Peartree Hill Solar Farm

Environmental Statement Addendum Revision ~~3~~² (tracked)

Application Document Ref: EN010157/APP/8.2

~~August-September~~ 2025

Figure 1.2: Land Areas and Cable Routes Plan with Field Numbering System

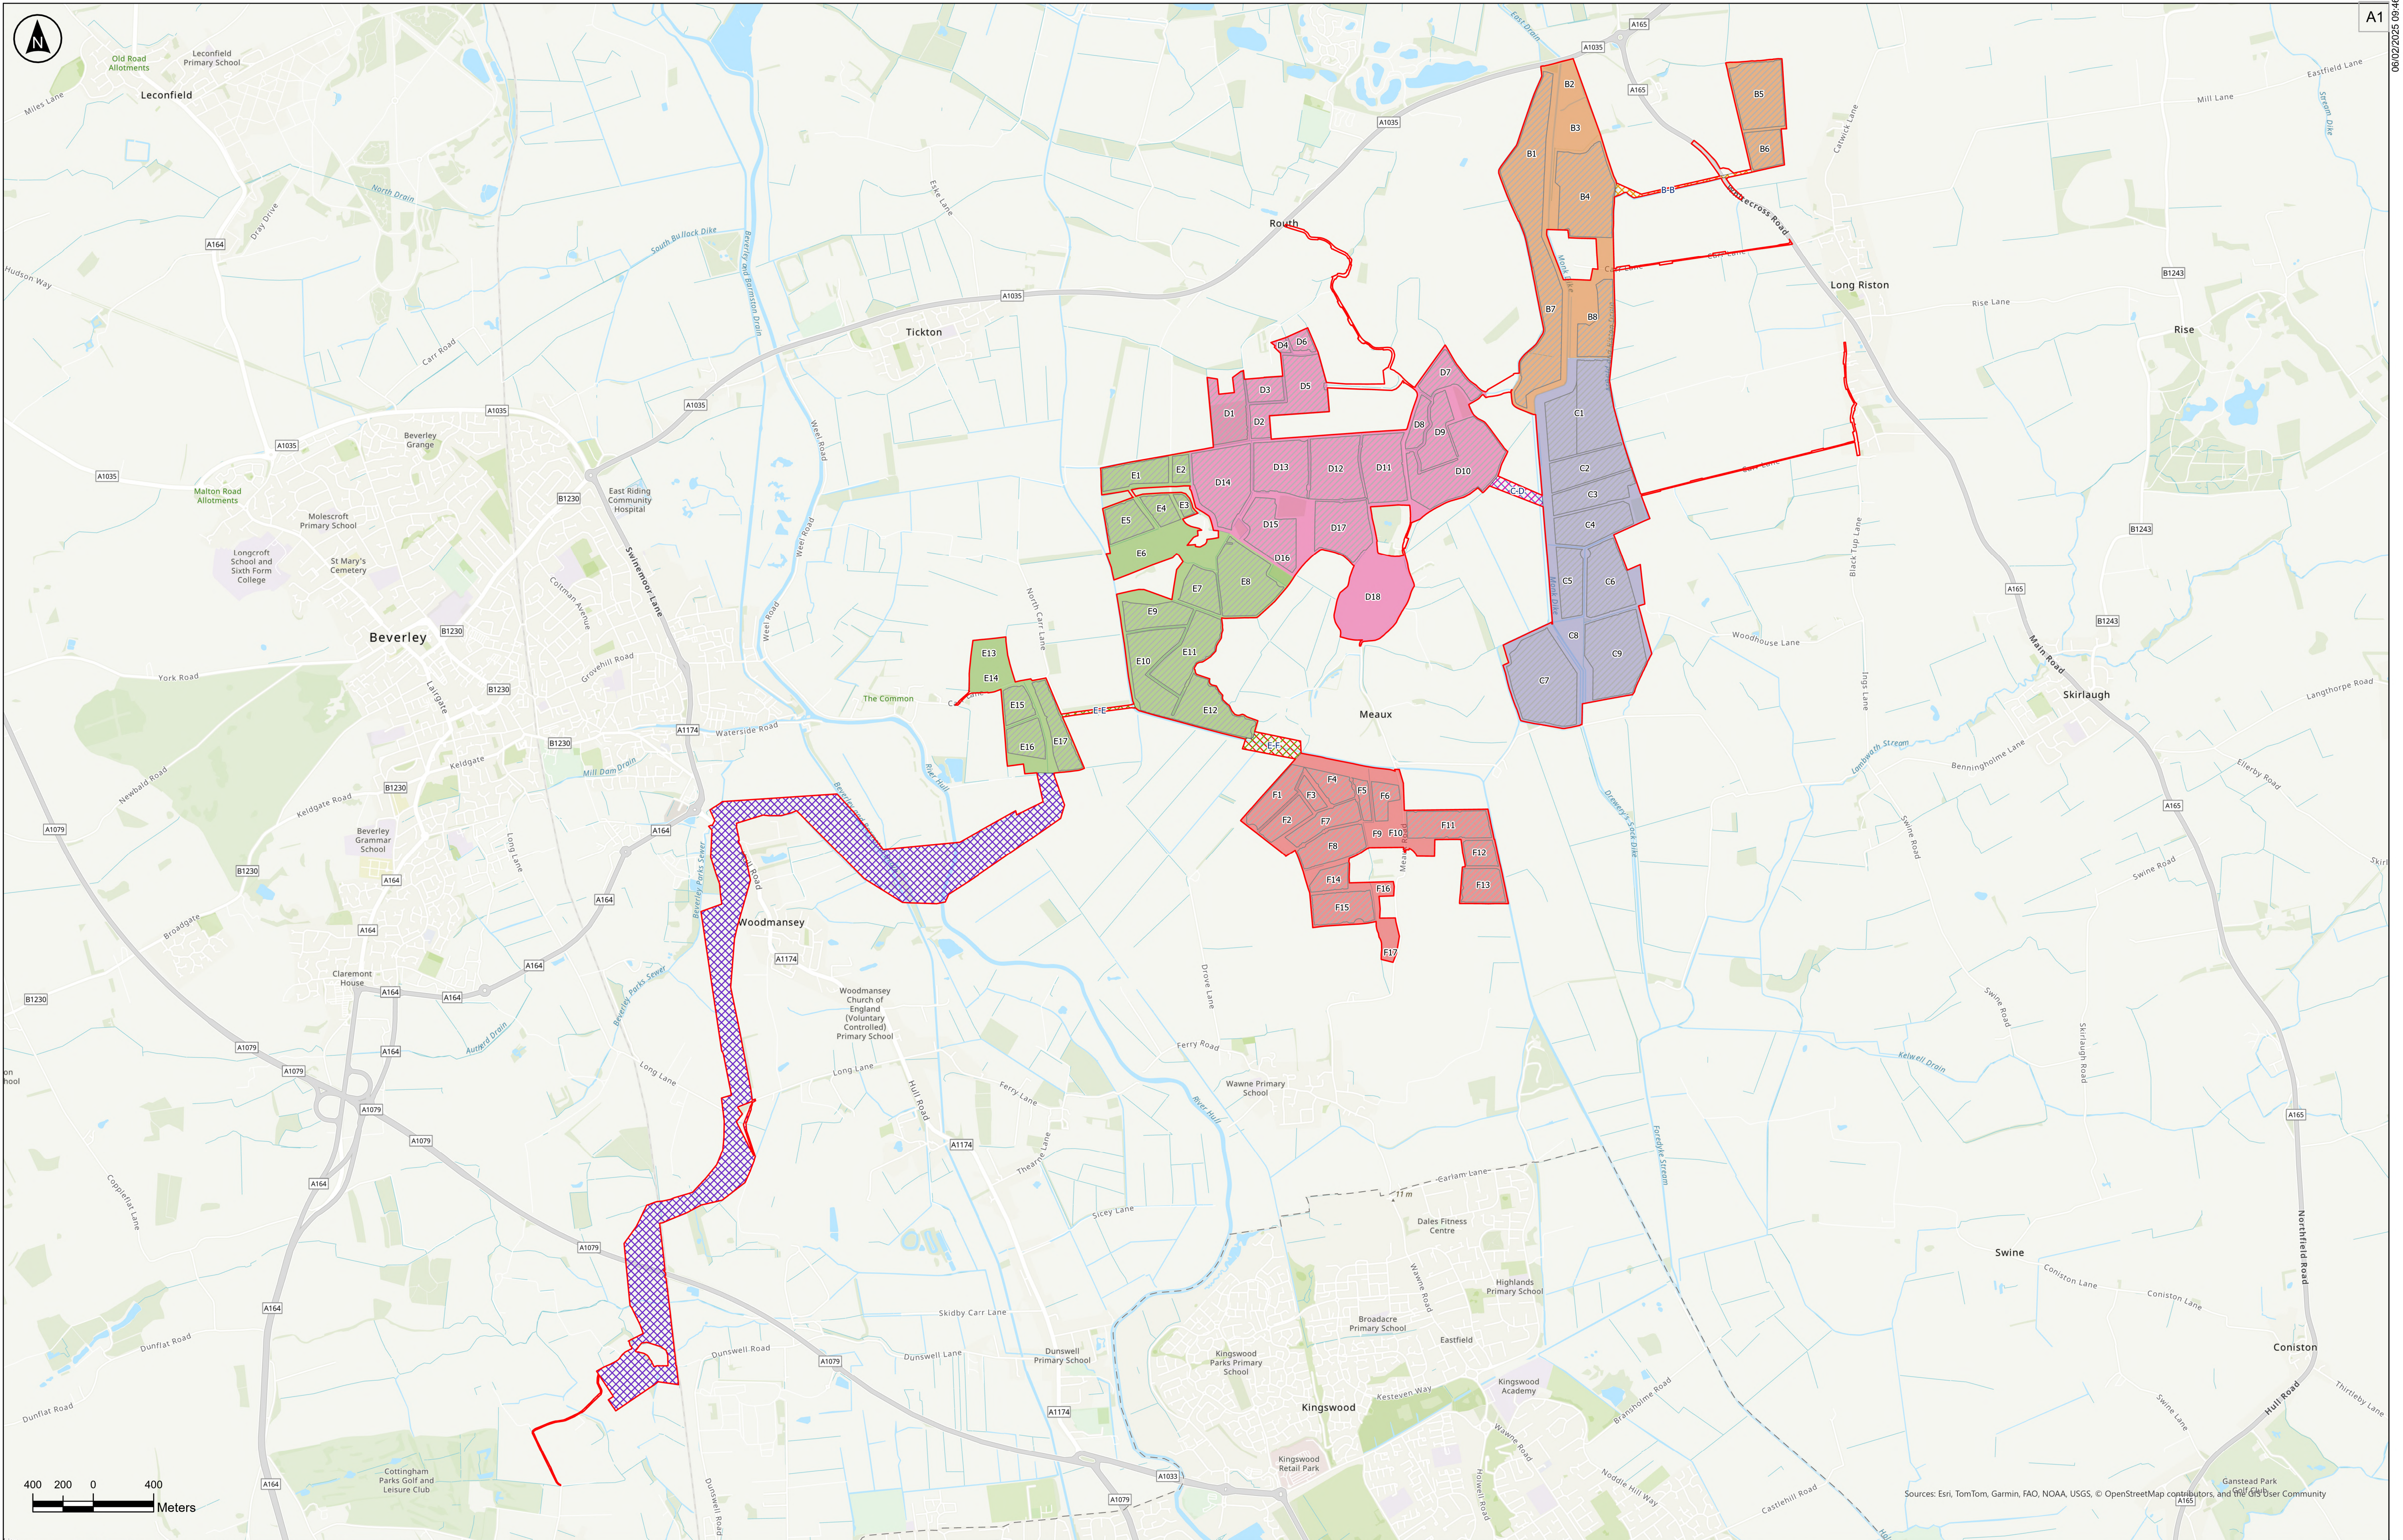
Document reference	Reason for amendment	ES Amendment July 2025
	Figure 1.2 also requires amendment to reflect the removal of plots 10-4, 10-5 and 10-6 as part of change/correction 2.	
ES Volume 3, Figure 2.1: Environmental Features Plan [APP-054]	Figure 2.1 requires amendment to reflect the removal of plots 10-4, 10-5 and 10-6 as part of change/correction 2.	
ES Volume 3, Figure 3.1: Indicative Operational Layout Plan [APP-055]	Figure 3.1 requires amendment to reflect the removal of a section of solar array from Land Area B as part of change/correction 1. Figure 3.1 also requires amendment to reflect the removal of plots 10-4, 10-5 and 10-6 as part of change/correction 2.	
ES Volume 3, Figure 3.2: Heights Parameters Zonal Plan [APP-056]	Figure 3.2 requires amendment to reflect the removal of a section of solar array from Land Area B as part of change/correction 1. Figure 3.2 also requires amendment to reflect the removal of plots 10-4, 10-5 and 10-6 as part of change/correction 2.

Figure 14.3: Public Rights of Way and Long Distance Paths Within and Adjacent to the Proposed Development

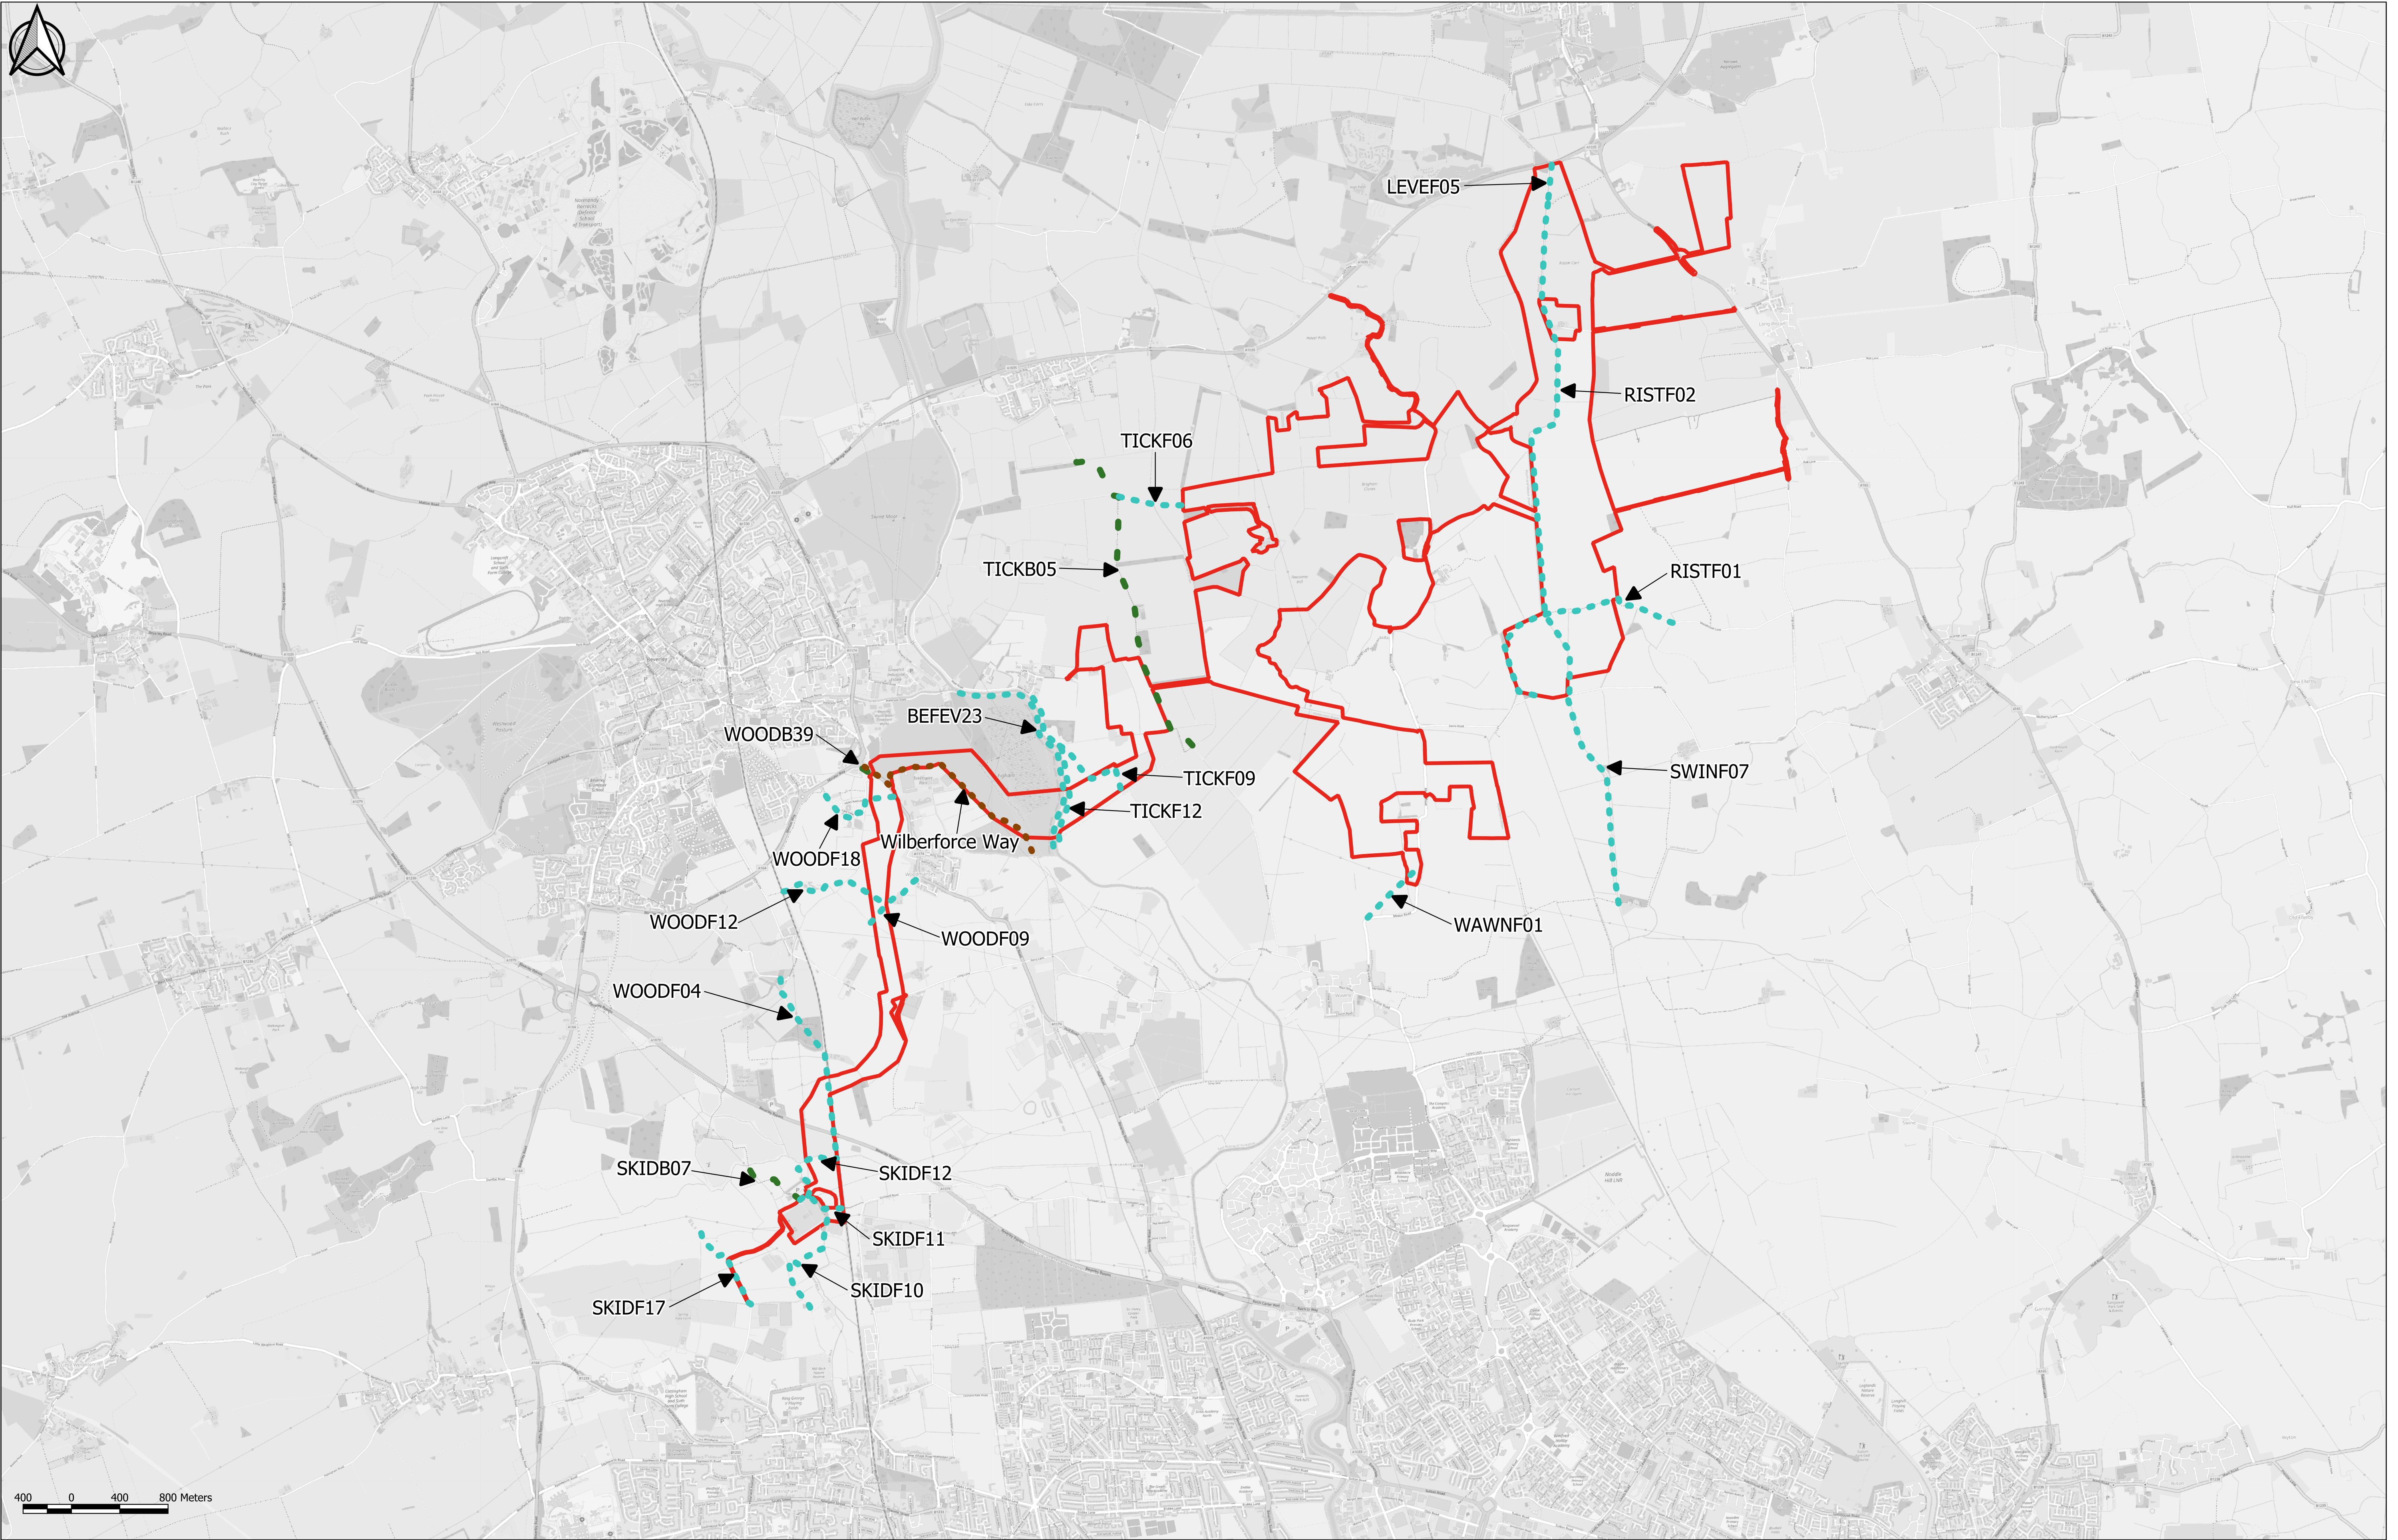
Document reference	Reason for amendment	ES Amendment July 2025
ES Volume 3, Figure 14.3: Public Rights of Way and Long Distance Paths Within and Adjacent to the Proposed Development [APP-091]	Figure 14.3 requires amendment to reflect the removal of plots 10-4, 10-5 and 10-6 as part of change/correction 2.	
ES Volume 3, Figure 14.4: Link Sensitivity [APP-092]	Figure 14.4 requires amendment to reflect the removal of plots 10-4, 10-5 and 10-6 as part of change/correction 2.	
ES Volume 3, Figure 15.1: Other Existing and/or Approved Development [APP-093]	Figure 15.1 requires amendment to reflect the removal of plots 10-4, 10-5 and 10-6 as part of change/correction 2.
